September 16, 2019

Re: Falcon Marketplace Final Plat (SF-19-001 CDR-16-007)

Please accept this response letter to comments received August 9th, 2019

**C1.13**

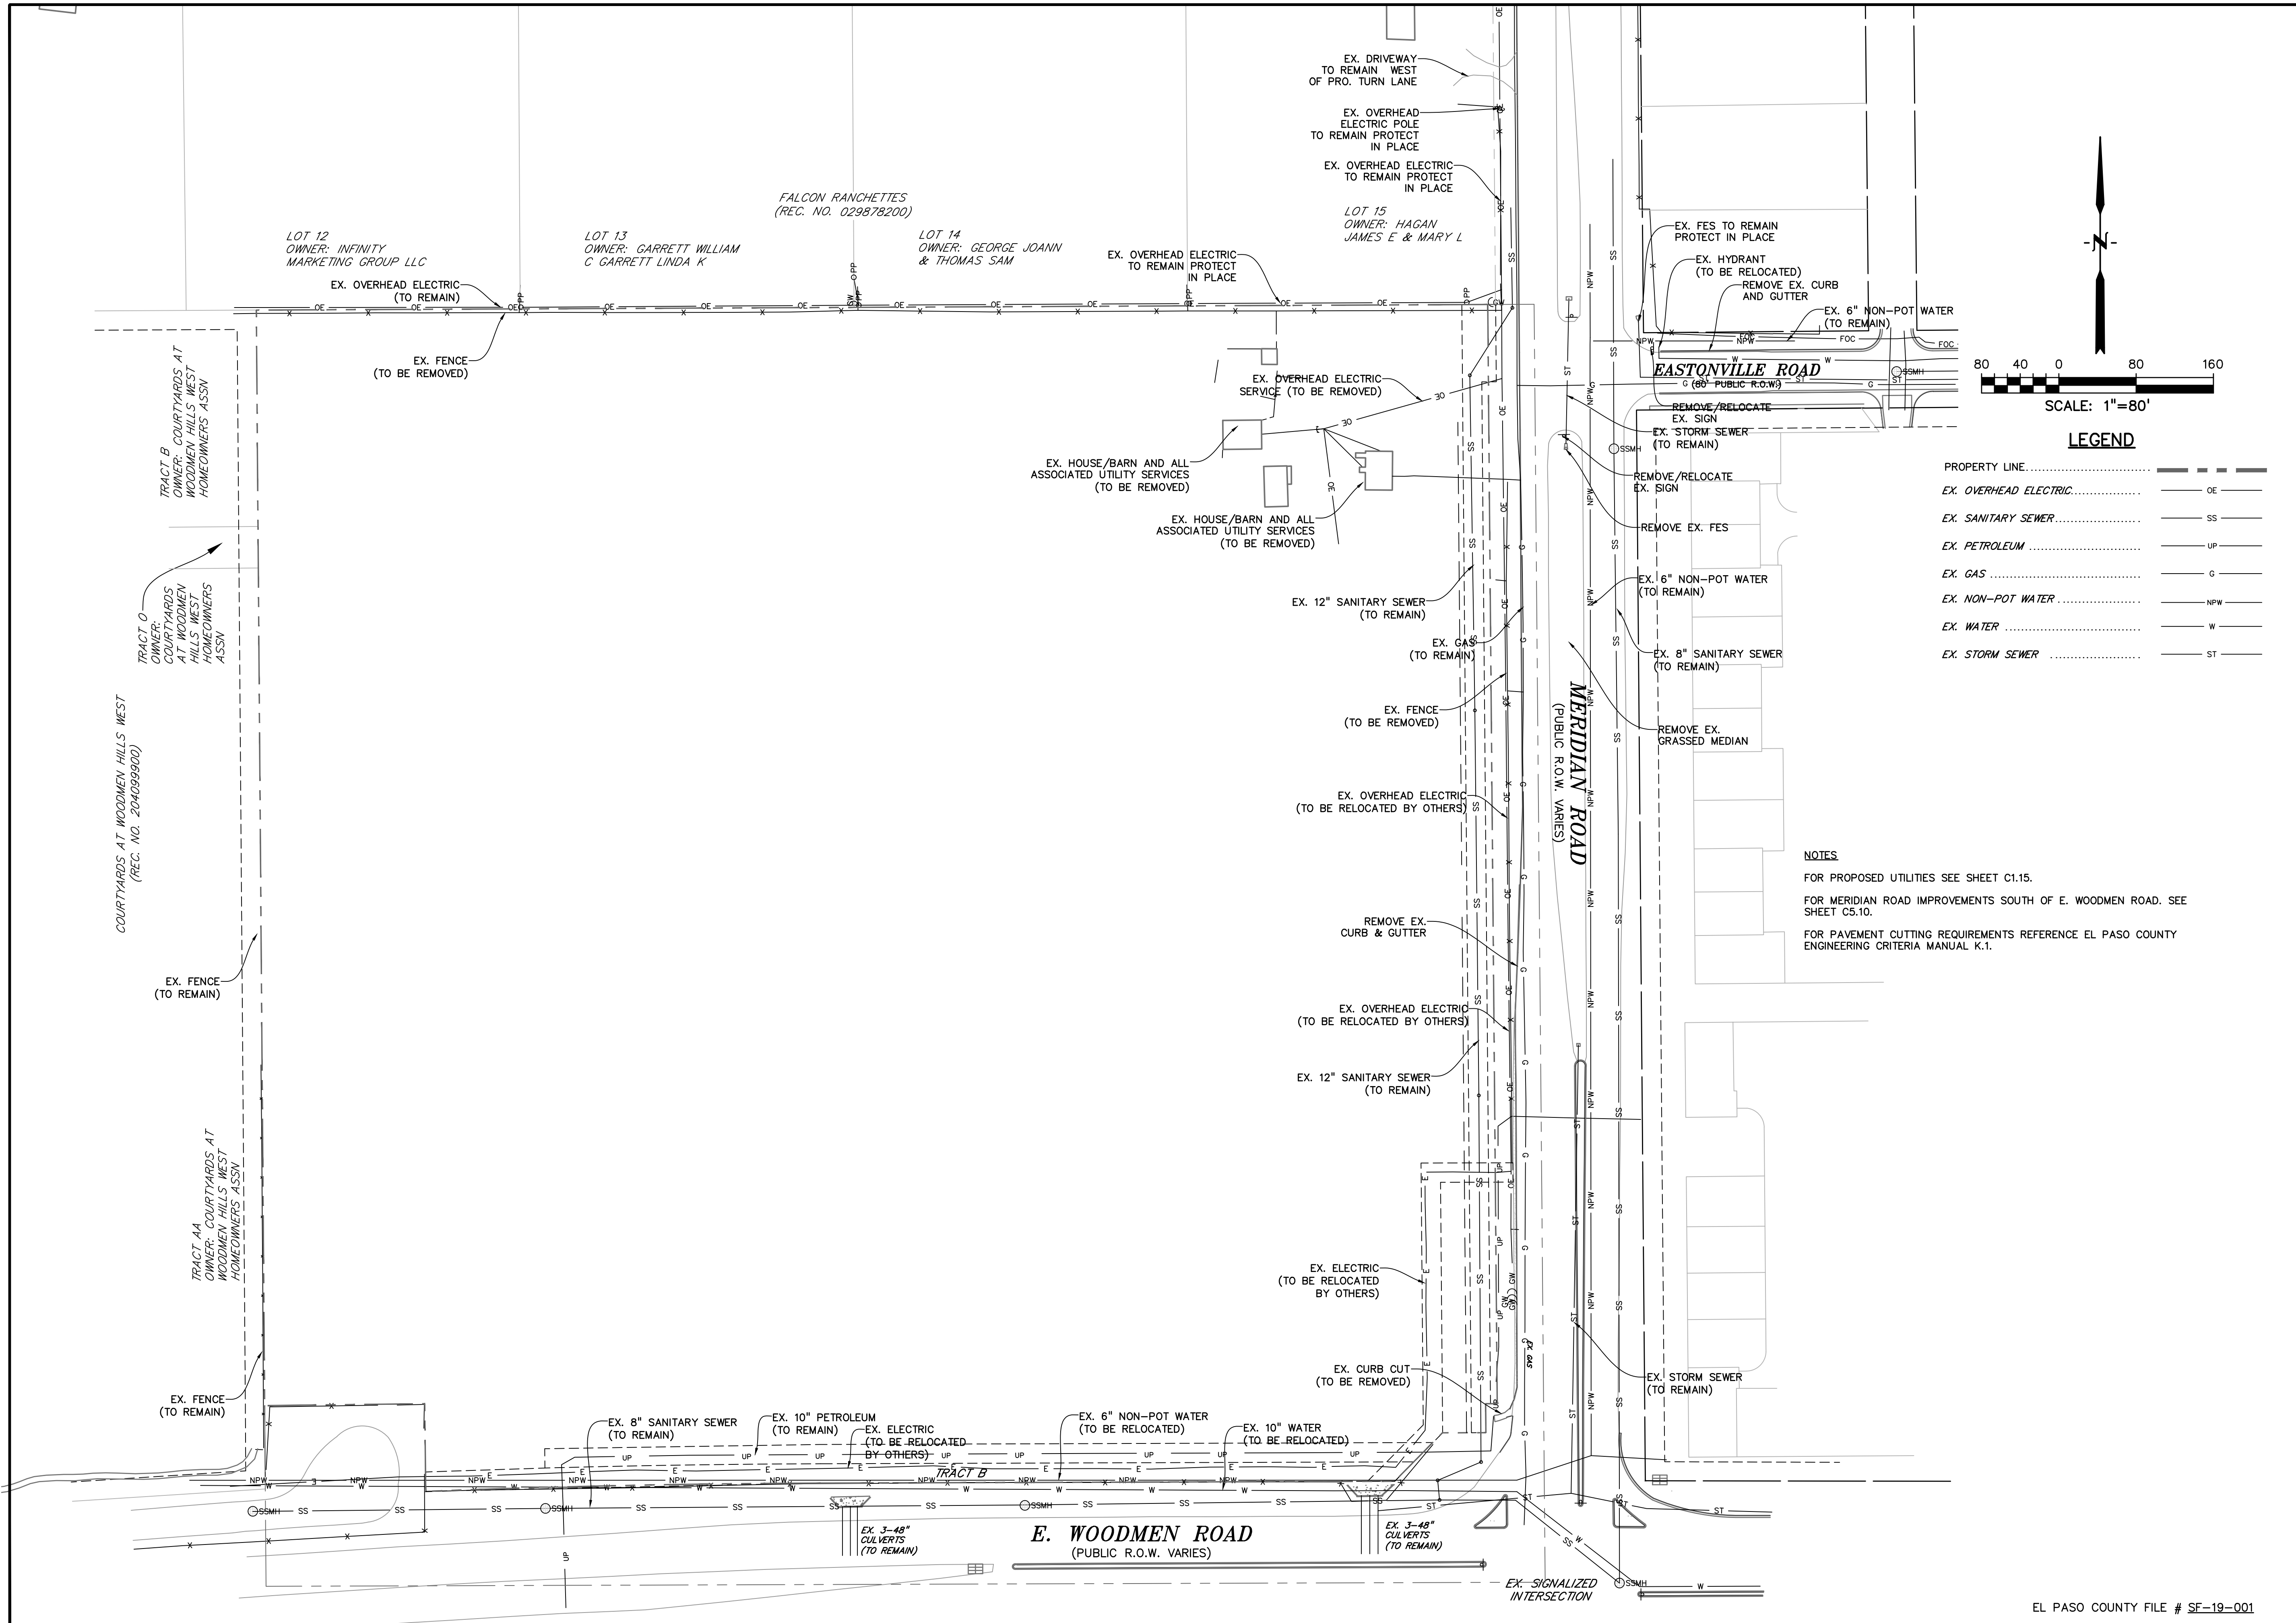
Dimension height

updated

DEMO & UTILITY  
RELOCATION  
PLAN

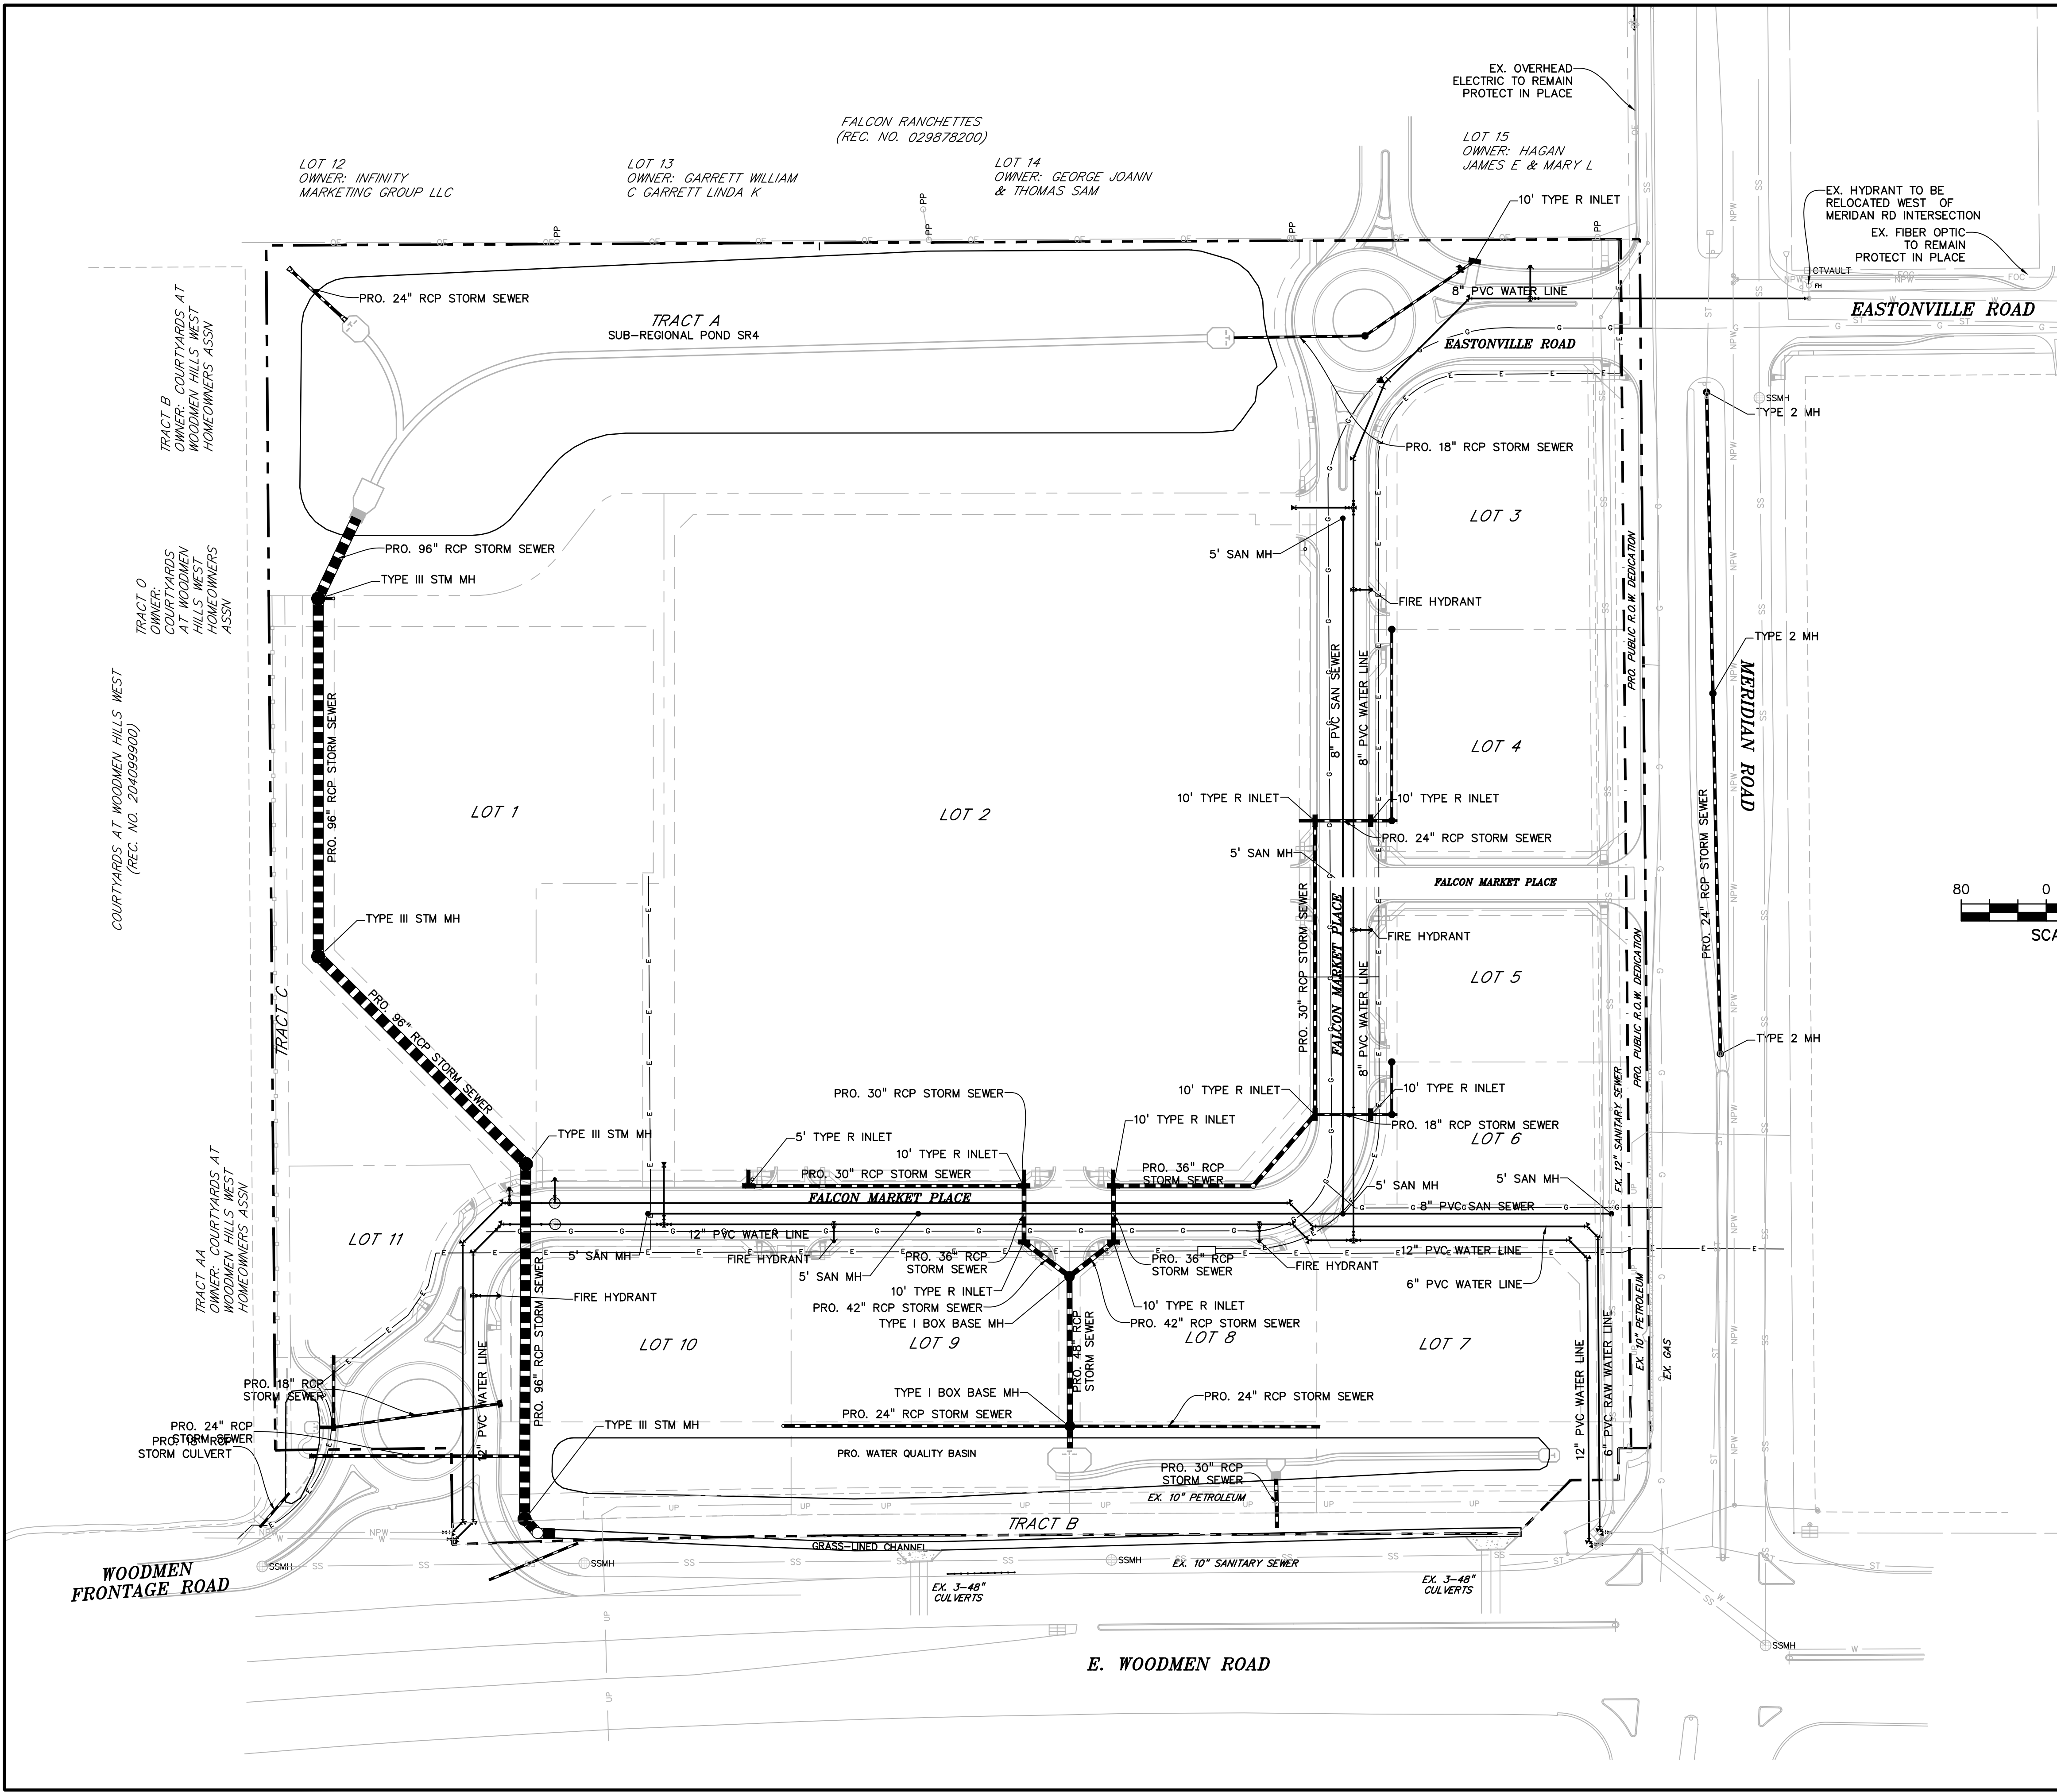
Does this pole have to be moved?

Reference ECM K.1 for pavement cutting requirements.

Pole to remain, section of guardrail added to plans

Note added

**C2.10**

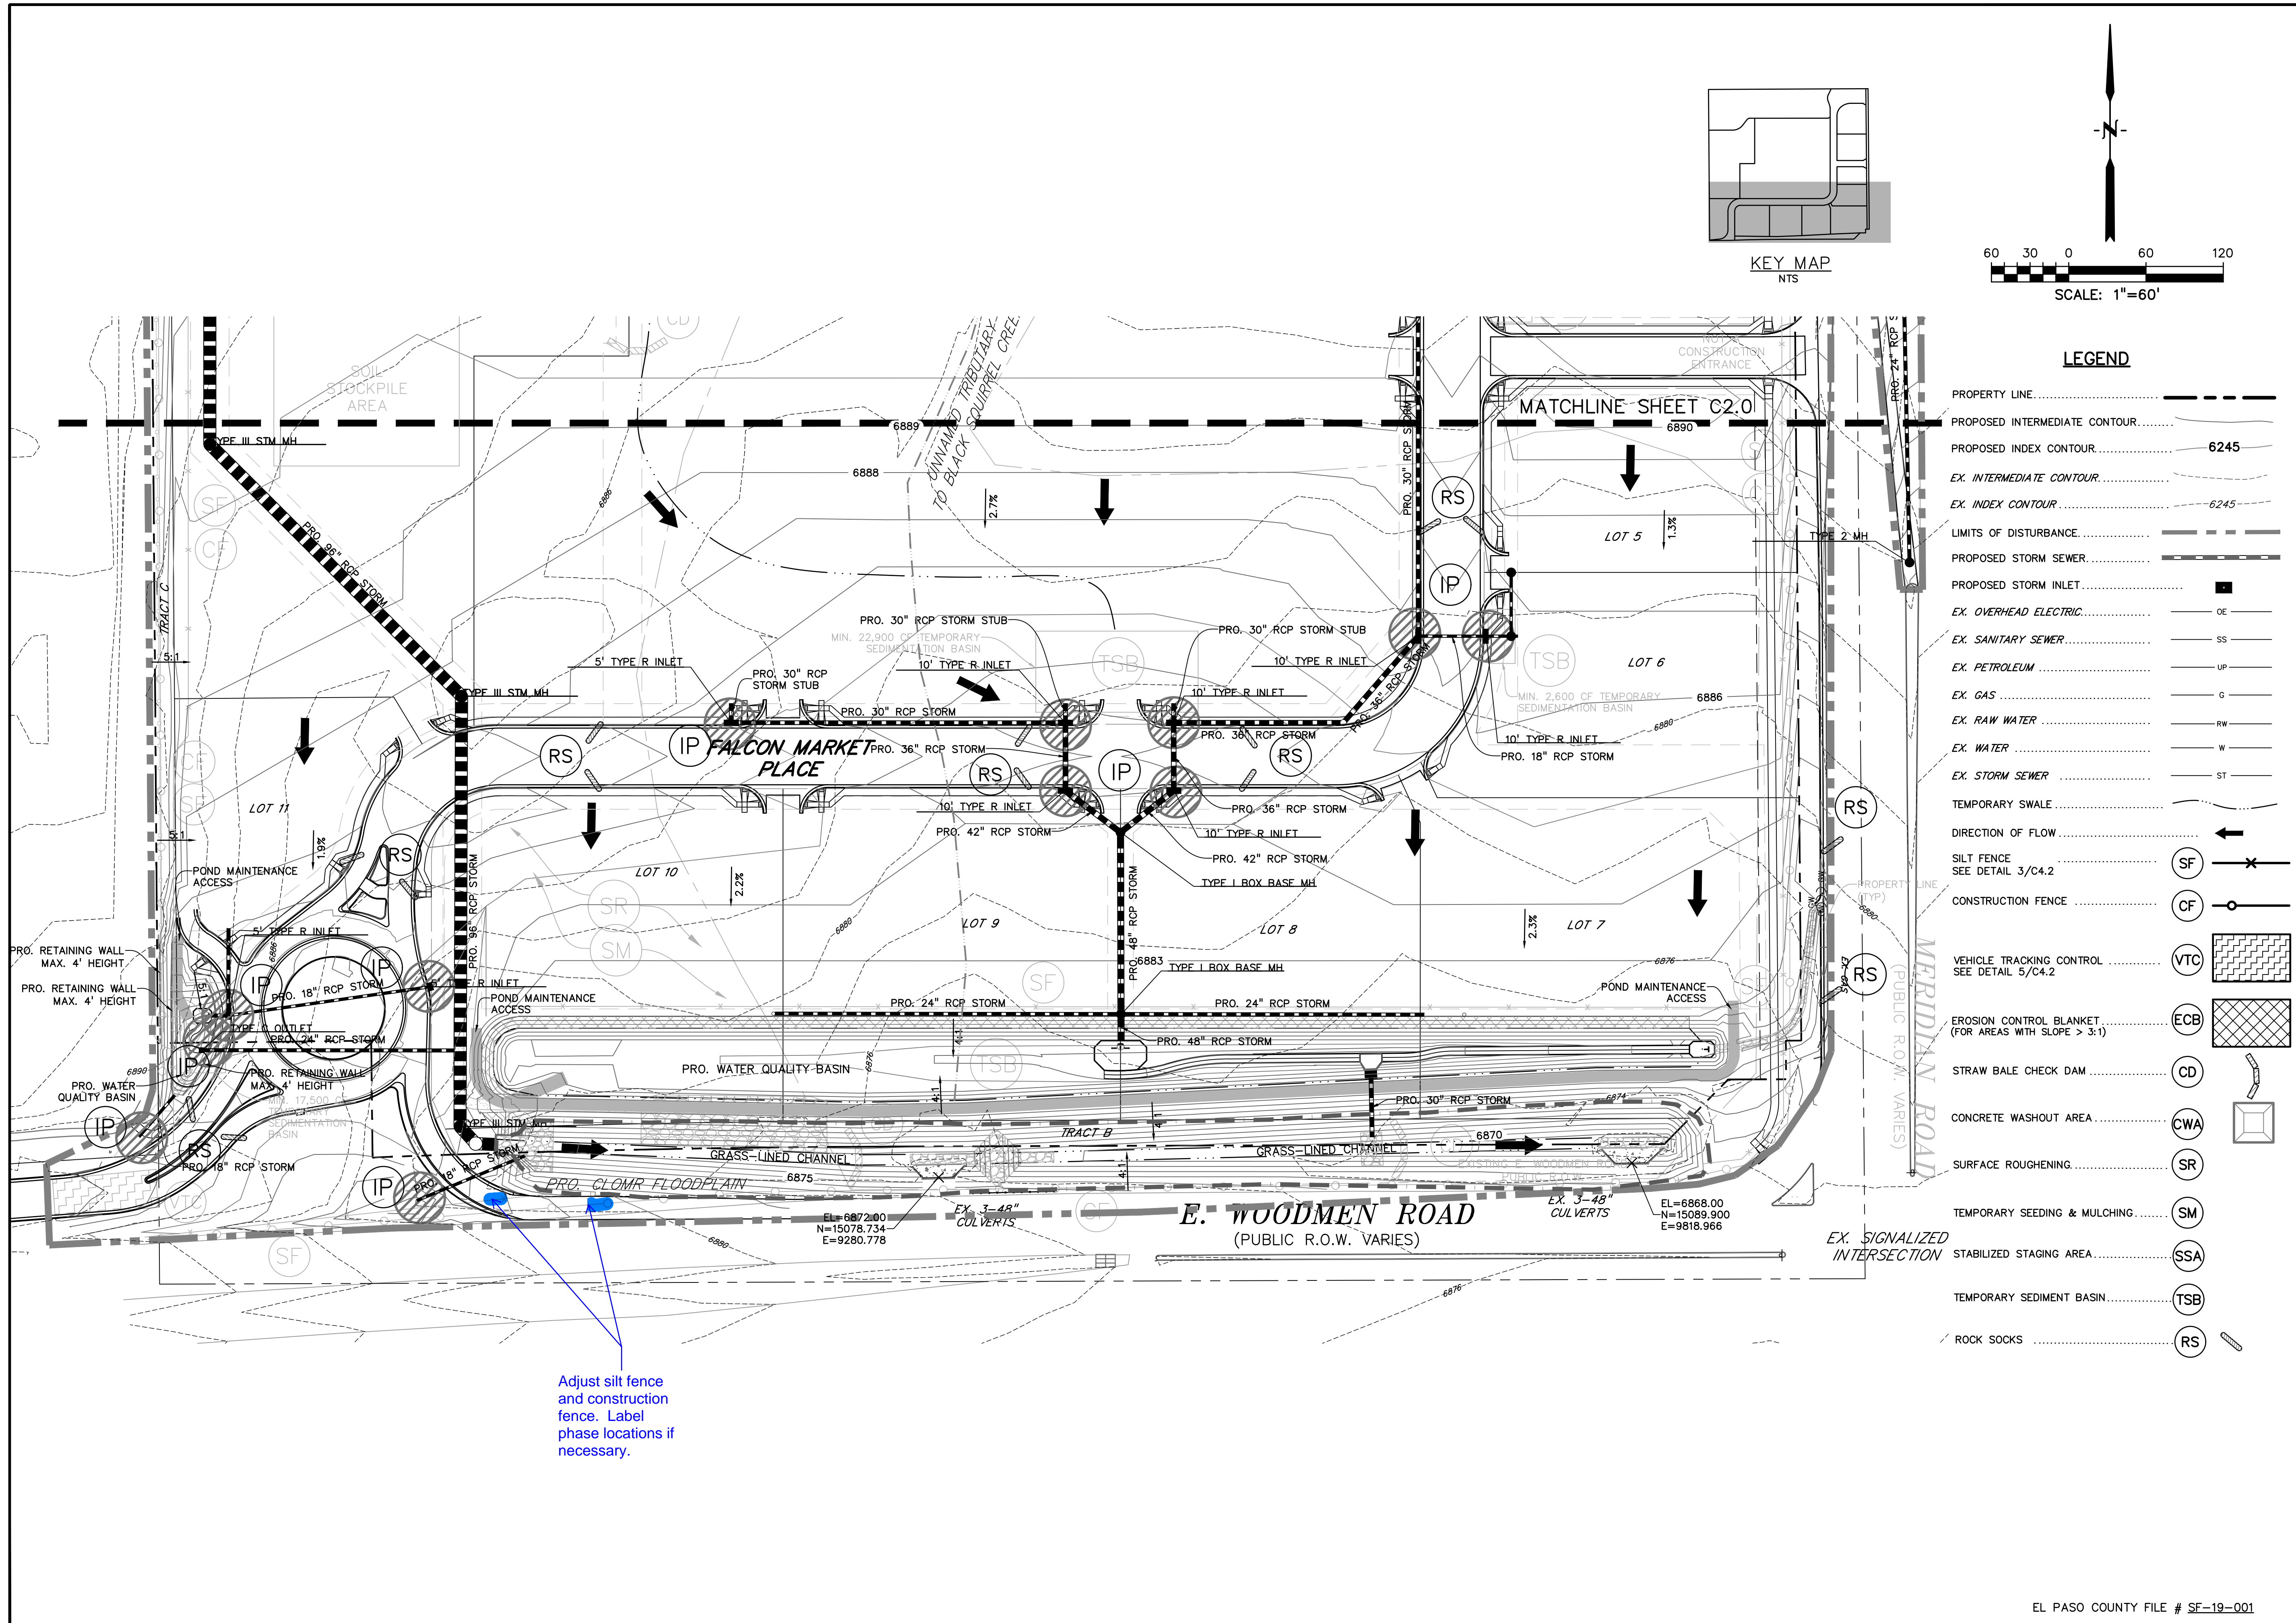
IP?

It appears that some work needs to be done on grading and apron. Provide details and easement if necessary.

Something is still not right here. Too many contour lines crossing?

Add:
 See Sheet ___ for details

Inlet protection added

Grading for driveway added. Temp grading easement will be coordinated with property owner.

Spillway location revised and maintenance access road also modified.

Added
